# Rezoning Transportation Analysis

Petition Number: 2024-011

**From:** Jake Carpenter, PE

Date	Description
02-21-24	First Review (TM)

Drawing Title:
Site Details

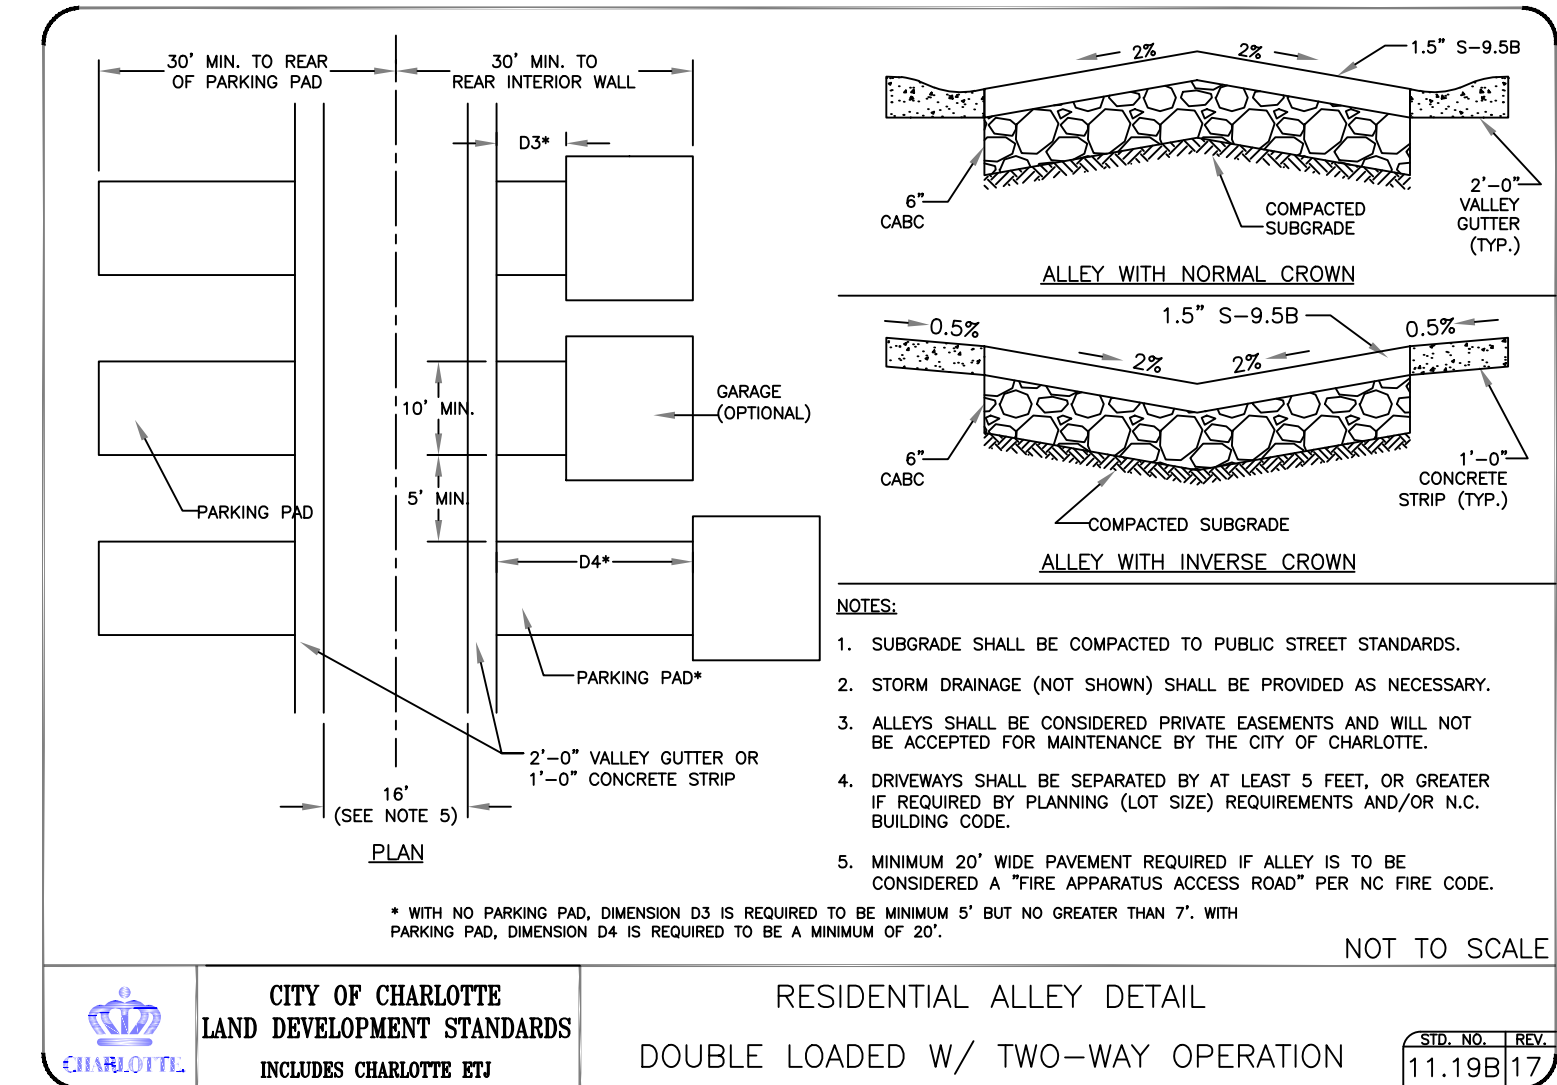
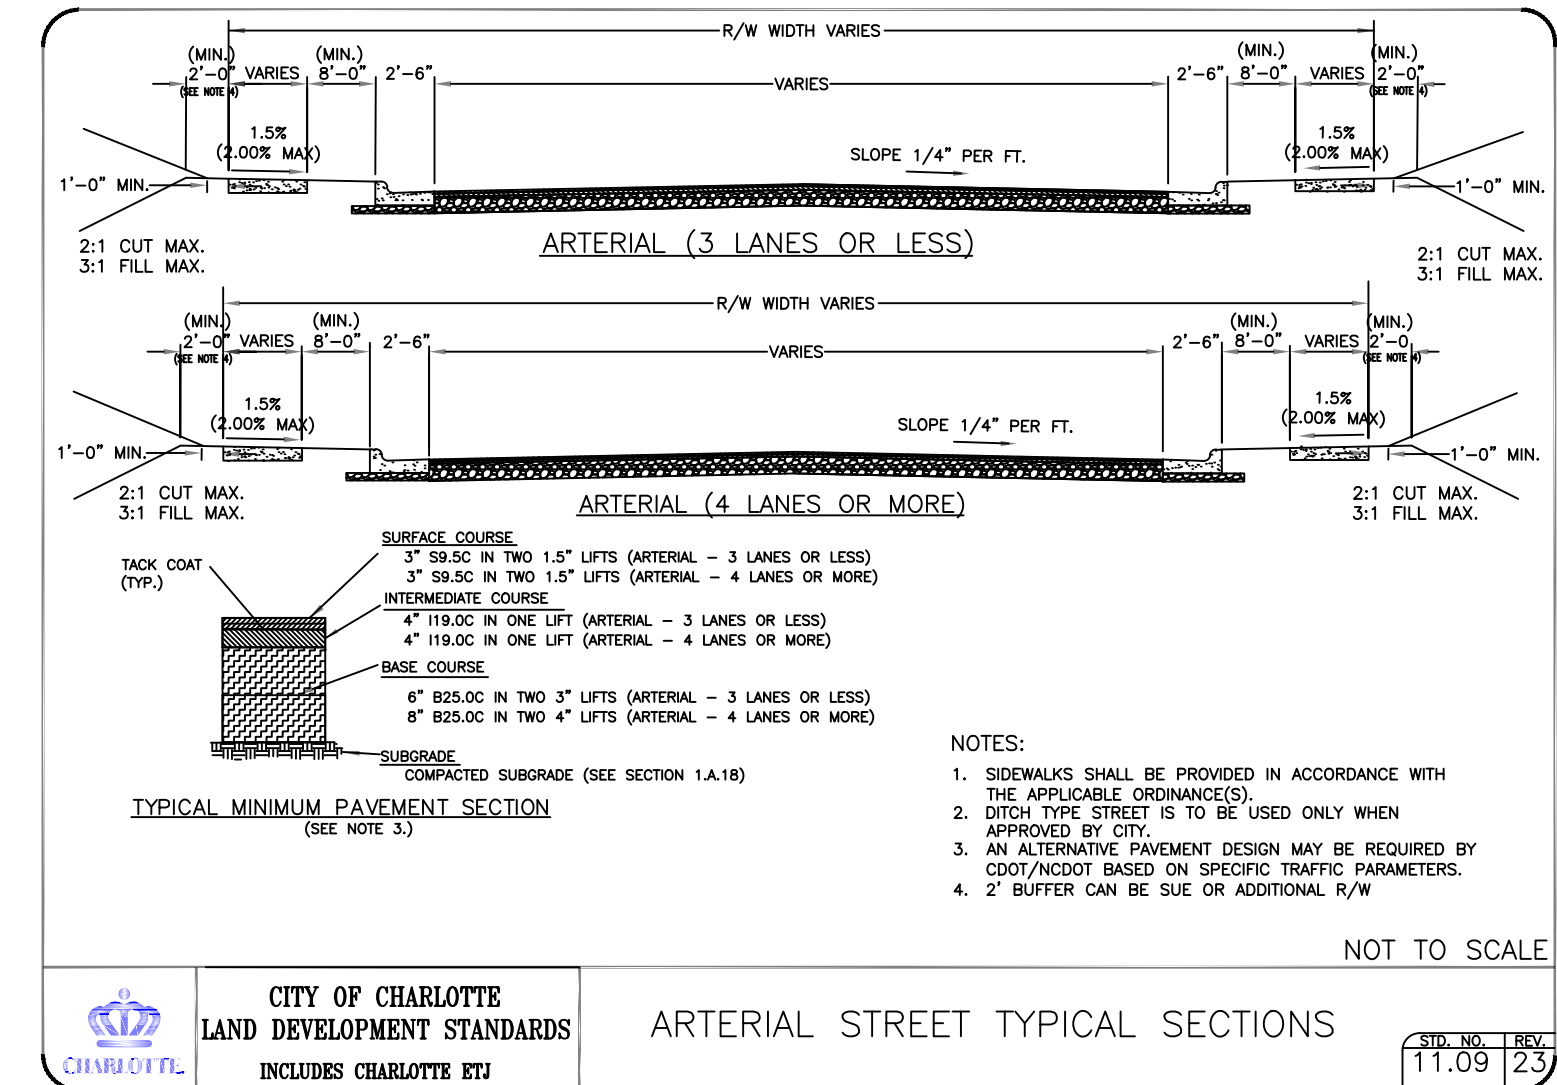
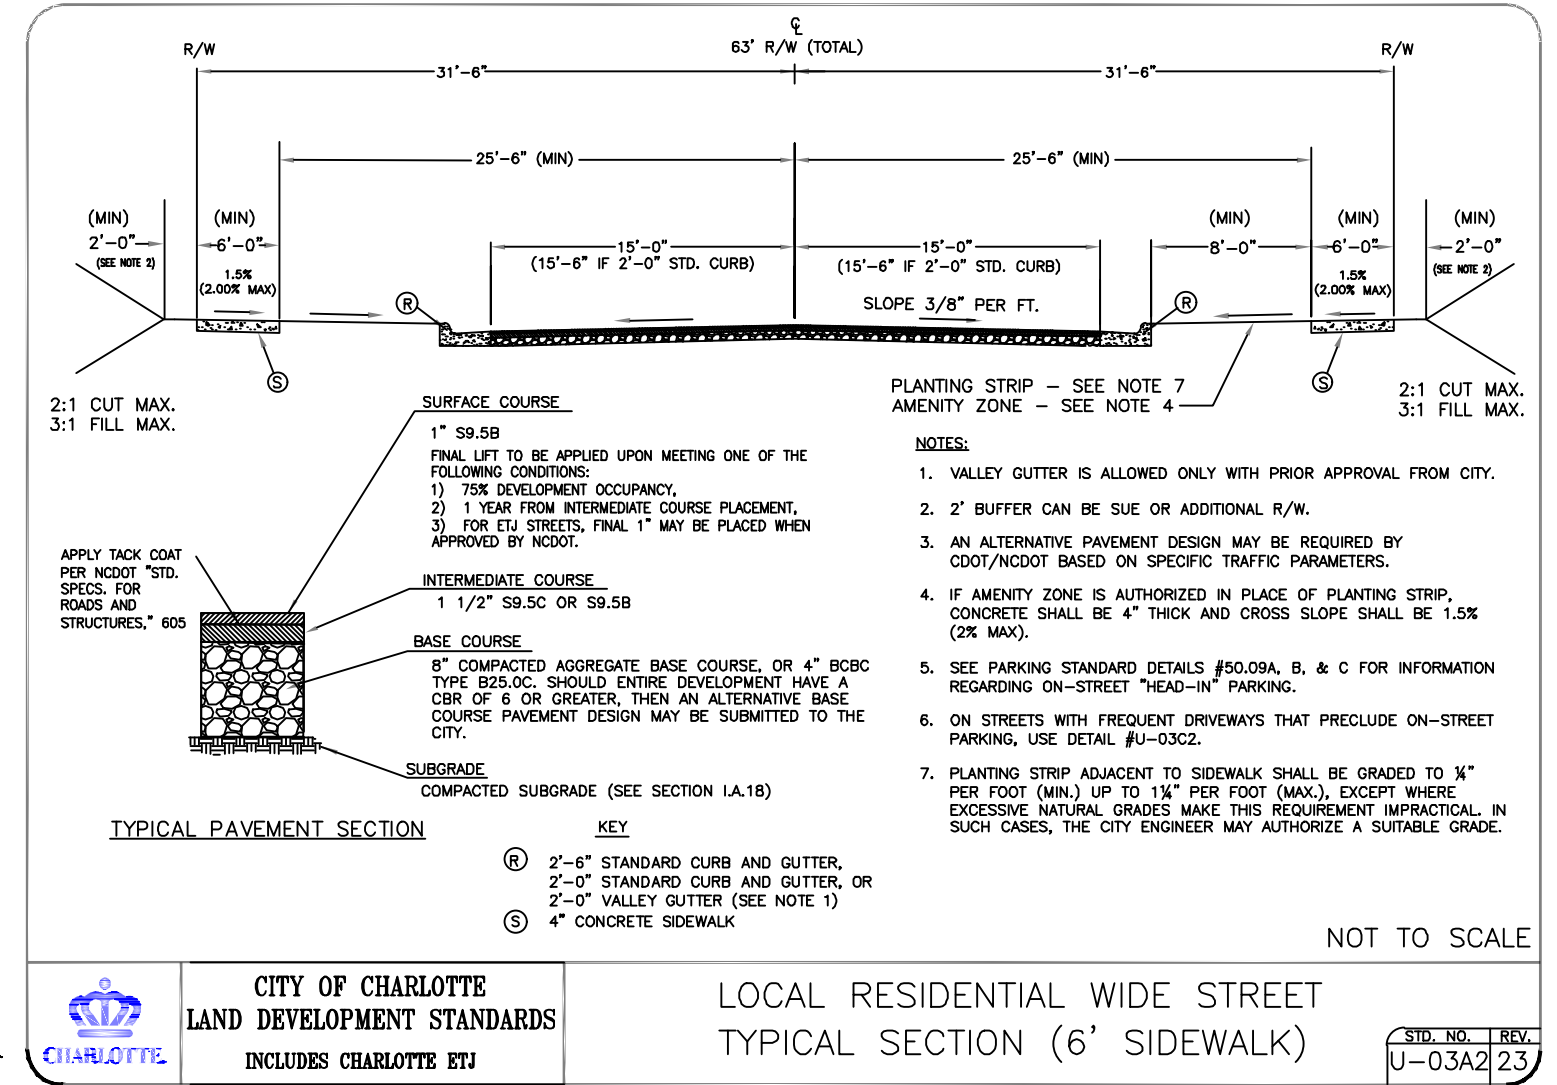
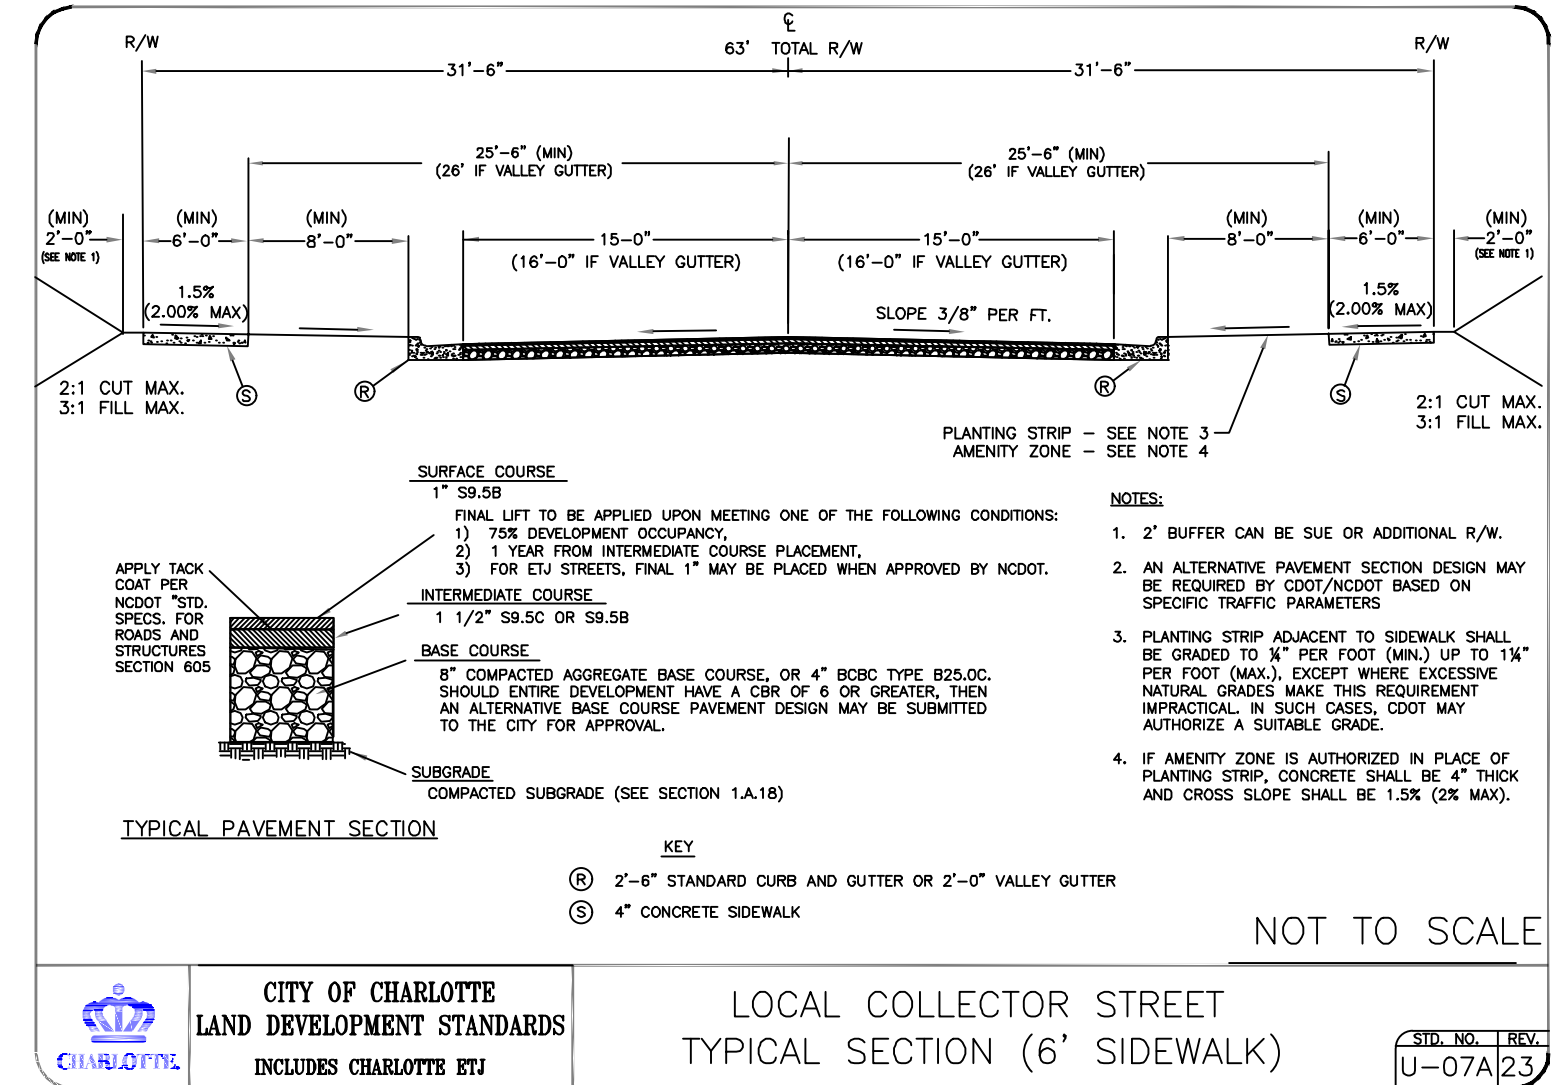
3. Revise site plan and conditional note(s) to commit to construct bicycle facilities by locating the curb and gutter 24' from the center line of Johnston Oehler Road in accordance with the council-adopted Charlotte Streets Map.

4. Revise site plan and conditional notes to construct internal public roadways as Local Residential Wide roadway (CLDSM U-03, U-03A1, U-03B and U-03C1) in accordance with table 33-2 in chapter 33 of the UDO.

5. Revise site plan and conditional notes to construct 8-foot sidewalk on all internal public roadways per table 33-4 in chapter 33 of the UDO.
6. Revise site plan and conditional notes to commit to removing existing driveway and curb cut on the west side of Johnston Oehler Road intersection.

Project No.	Drawing No.
5783	
DWG File Name:	
5783 - Rezoning Site Plan	C1.02

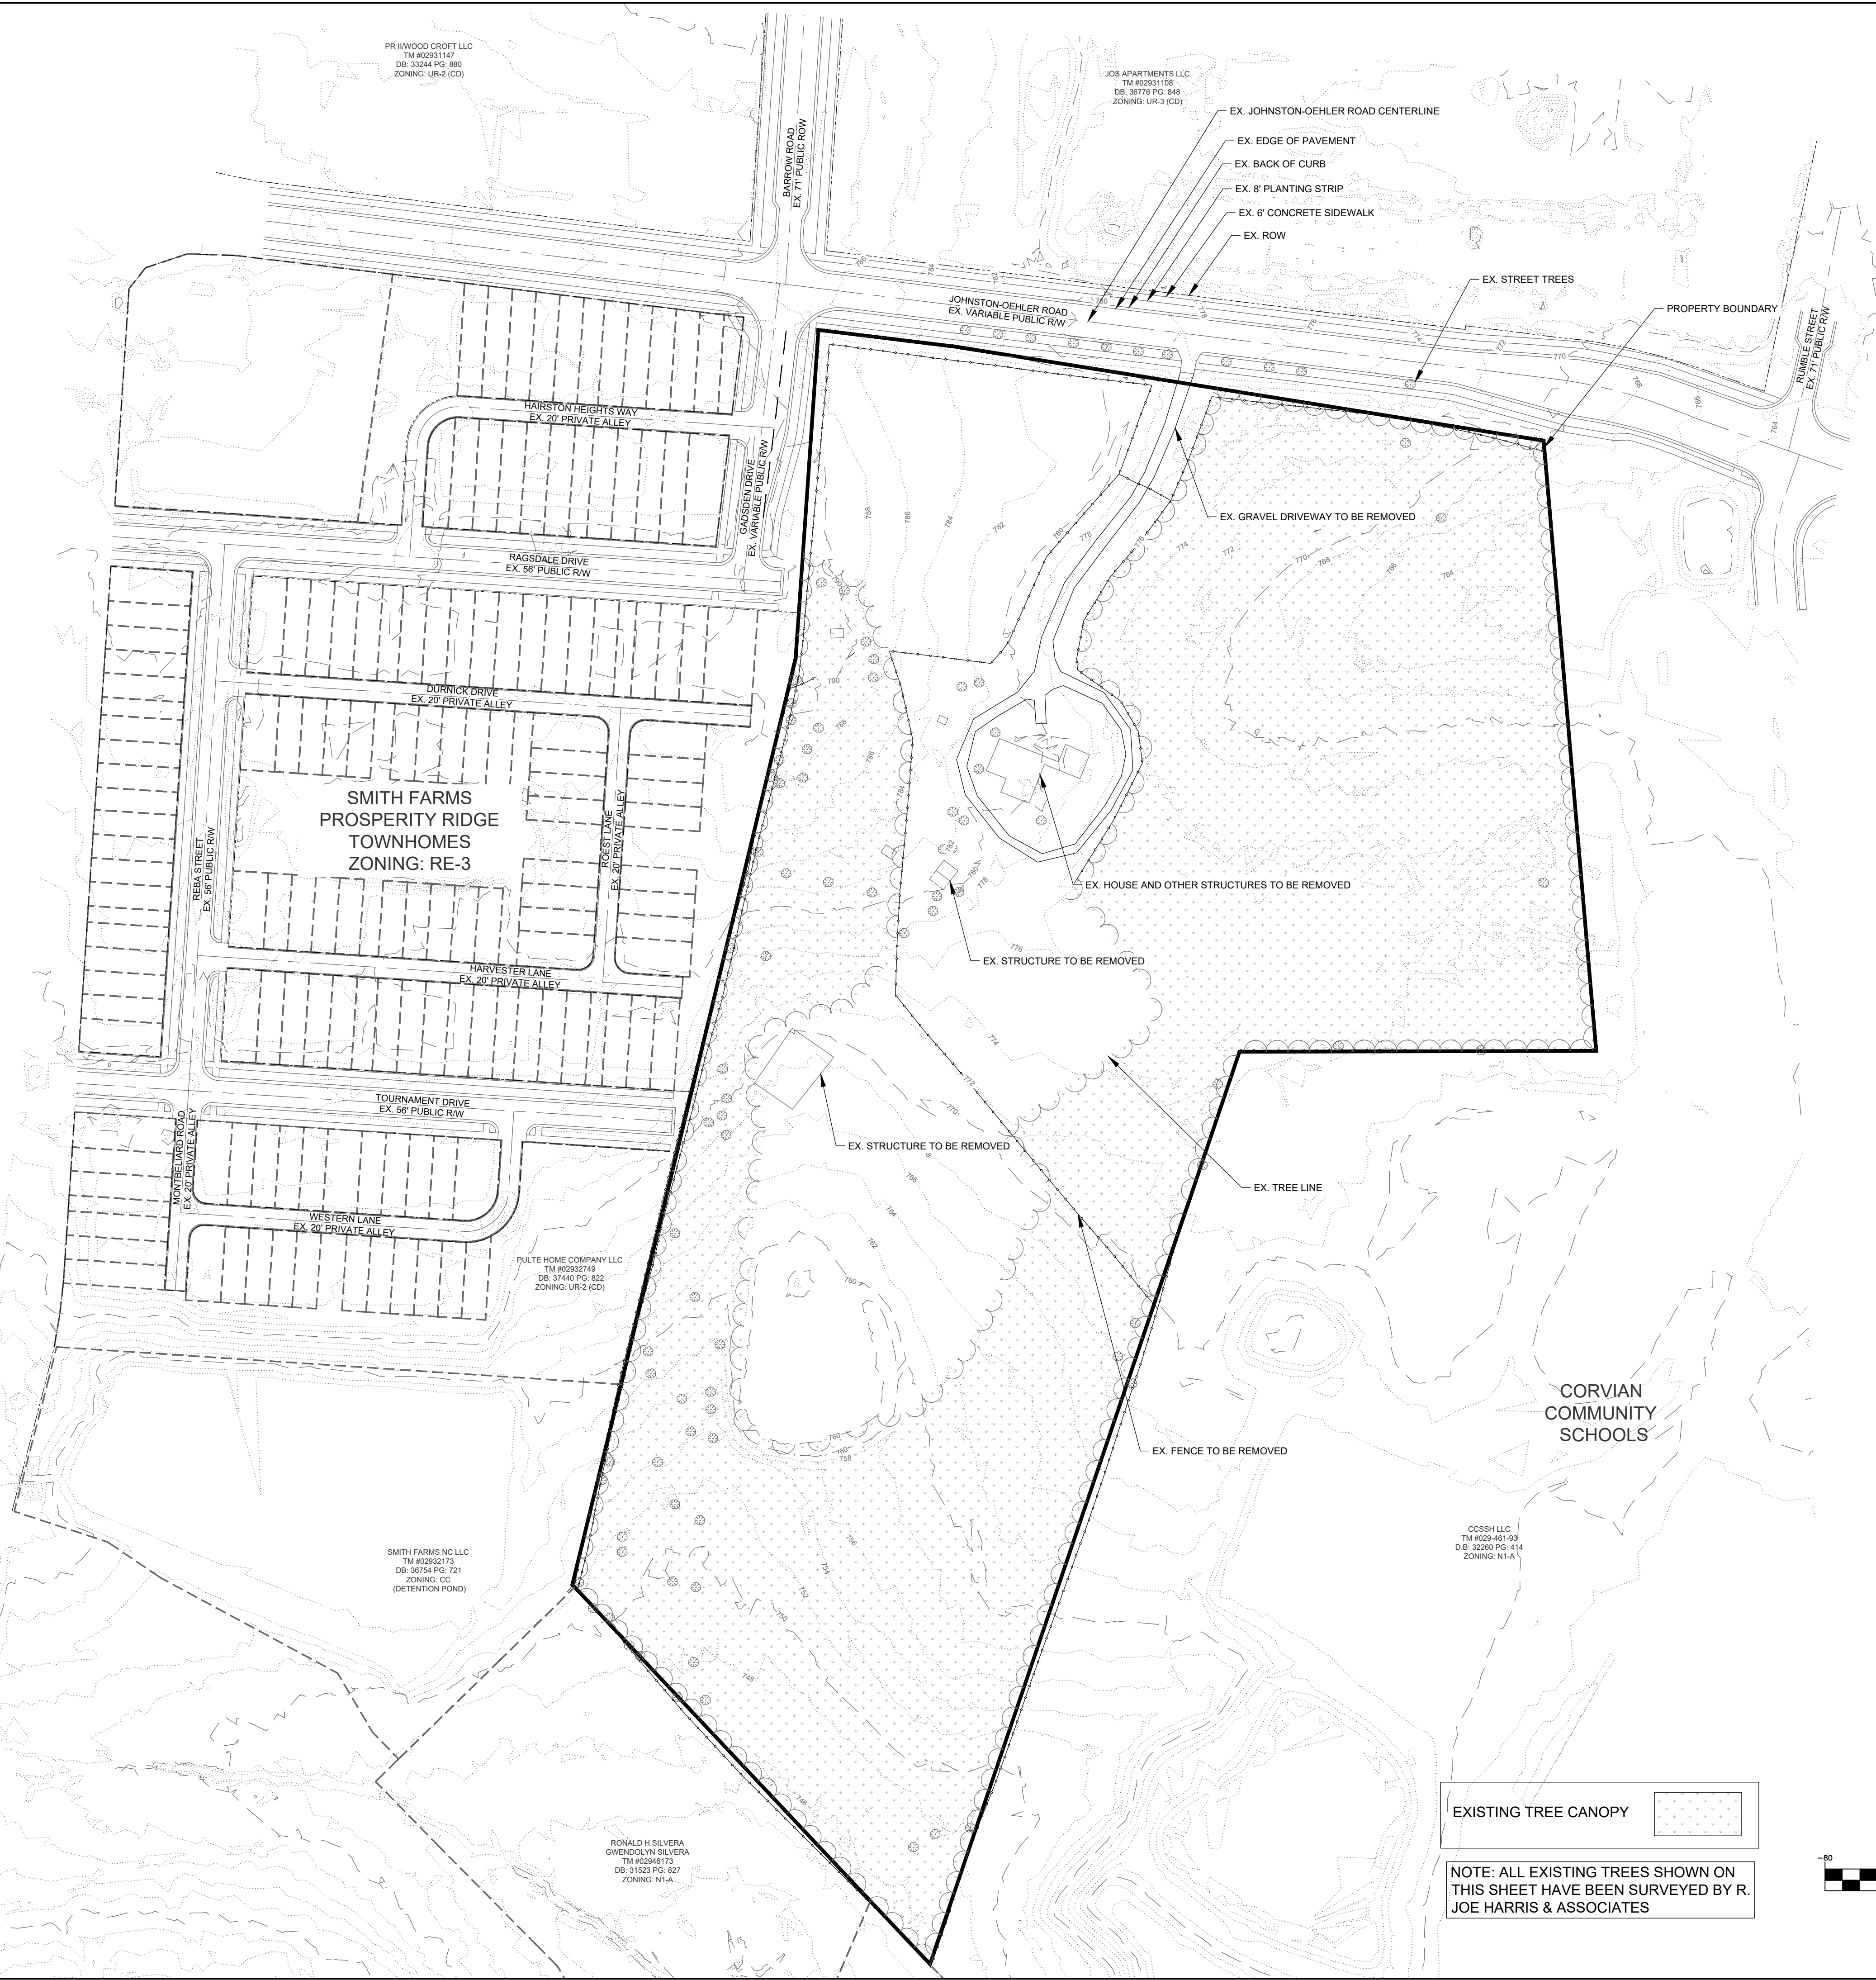
- a. **Johnston Oehler Road:** Location of future curb and gutter is to be relocated to 24-feet from the roadway centerline. Per CLDSM 11.09.

Label and dimension the curb and gutter from the centerline for each road on the site plan.

7. Revise site plan and conditional notes to revise site connection to Johnston Oehler Road to be a right in right out design. Site shall install a median that extends 50-feet beyond the site entrance measured from the curb return on east and west side of site intersection to Johnston Oehler Road.
